# Markup Summary

Daniel Torres (16)

# Preliminary Plan for ABERT RANCH SUBDIVISION

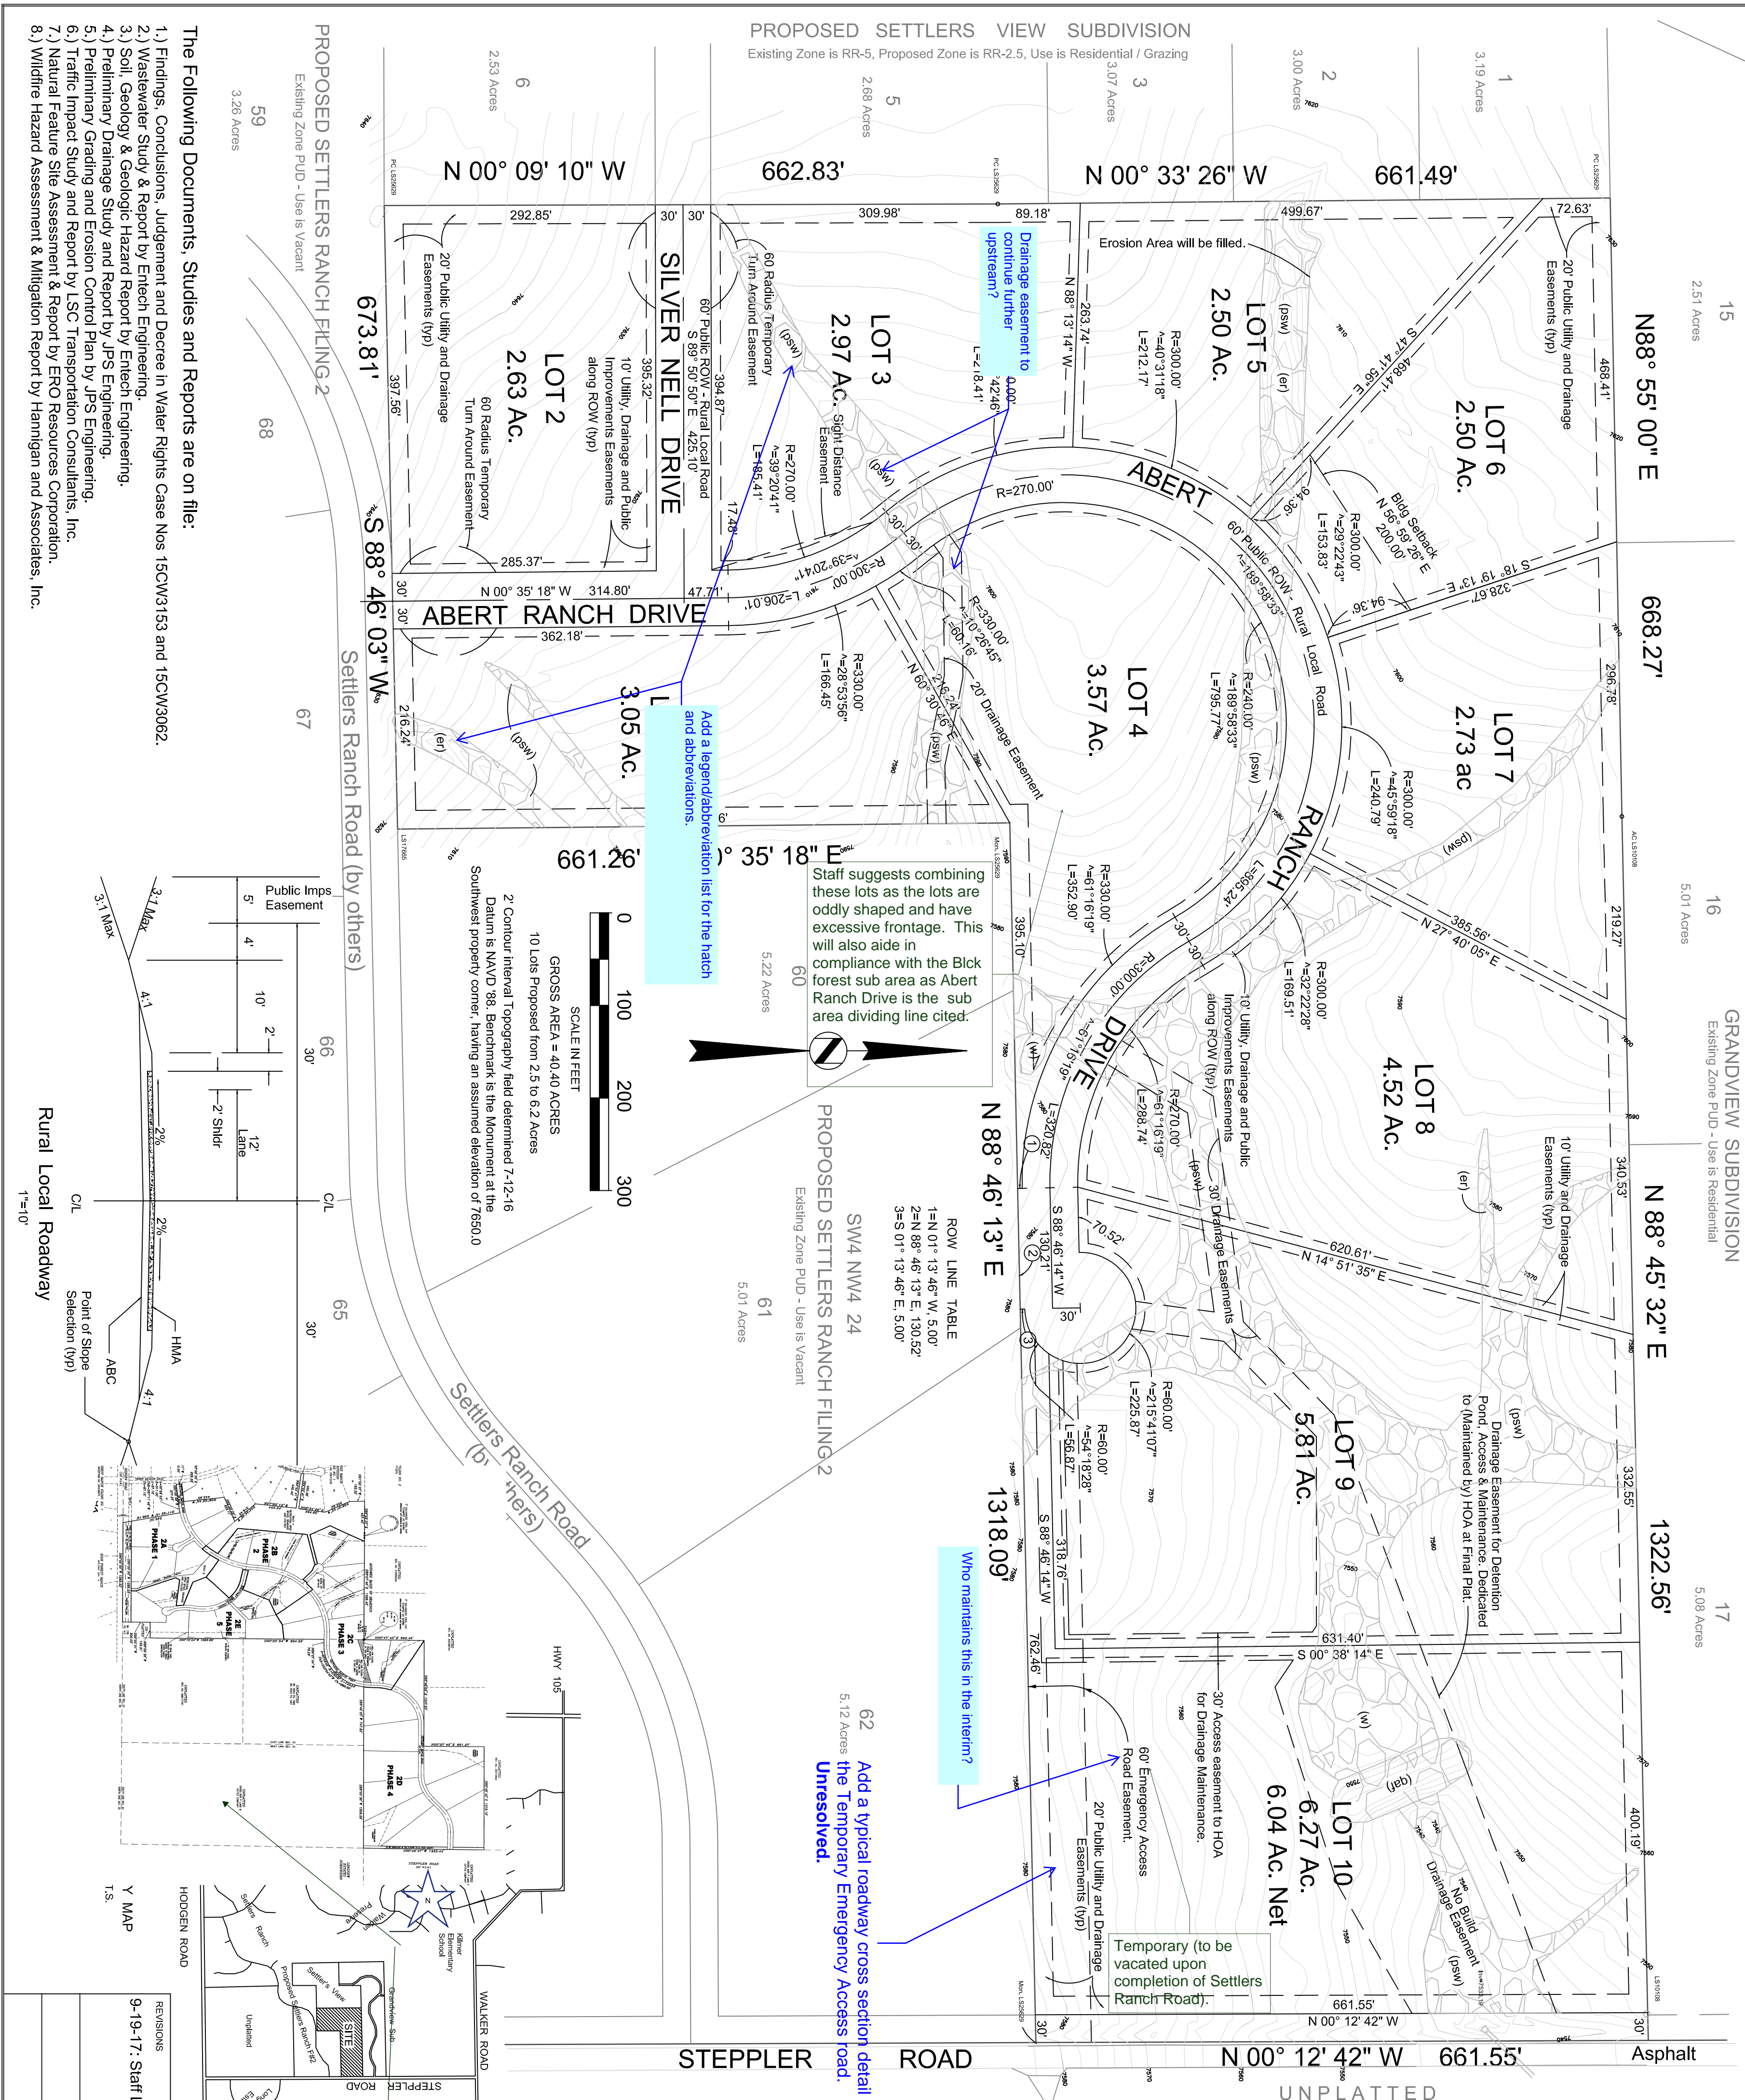
Provide bearing and distance information for drainage easement.

Update to current FEMA FIRM panel number and date

Please indicate the ROW dedication to El Paso county

Please remove temporary turnaround as Silver Nell is planned to be constructed providing necessary access to this subdivision

Provide easement for channel. See comment on drainage report.

Please indicate that Settlers Ranch Rd is to be the emergency access road.

Drainage easement to continue upstream as shown on the drainage plan.

Increase the width of the drainage easement to contain the top width of the channel (100 yr flow). See comment on Drainage plan

No lots may be subdivided a max of 10 lots is allowed

add note offsite easement/tract for ER access provided through tract ? of Settlers Ranch 2C and will be built by X and maintained by X until Settlers Ranch Road is brought up to County Road standards as a public road by the developer to the south.

Your missing the drainage easements necessary to include the constraints identified in the GEO report with the Prelim plan. Also add the geo notes to the notes of the plat.

This is not needed if Mark records and you have access to build the emergency access through his property. The CDS should reflect that if that is what you are proposing so there is no need to encumber, vacate and revegetate lots 9 & 10
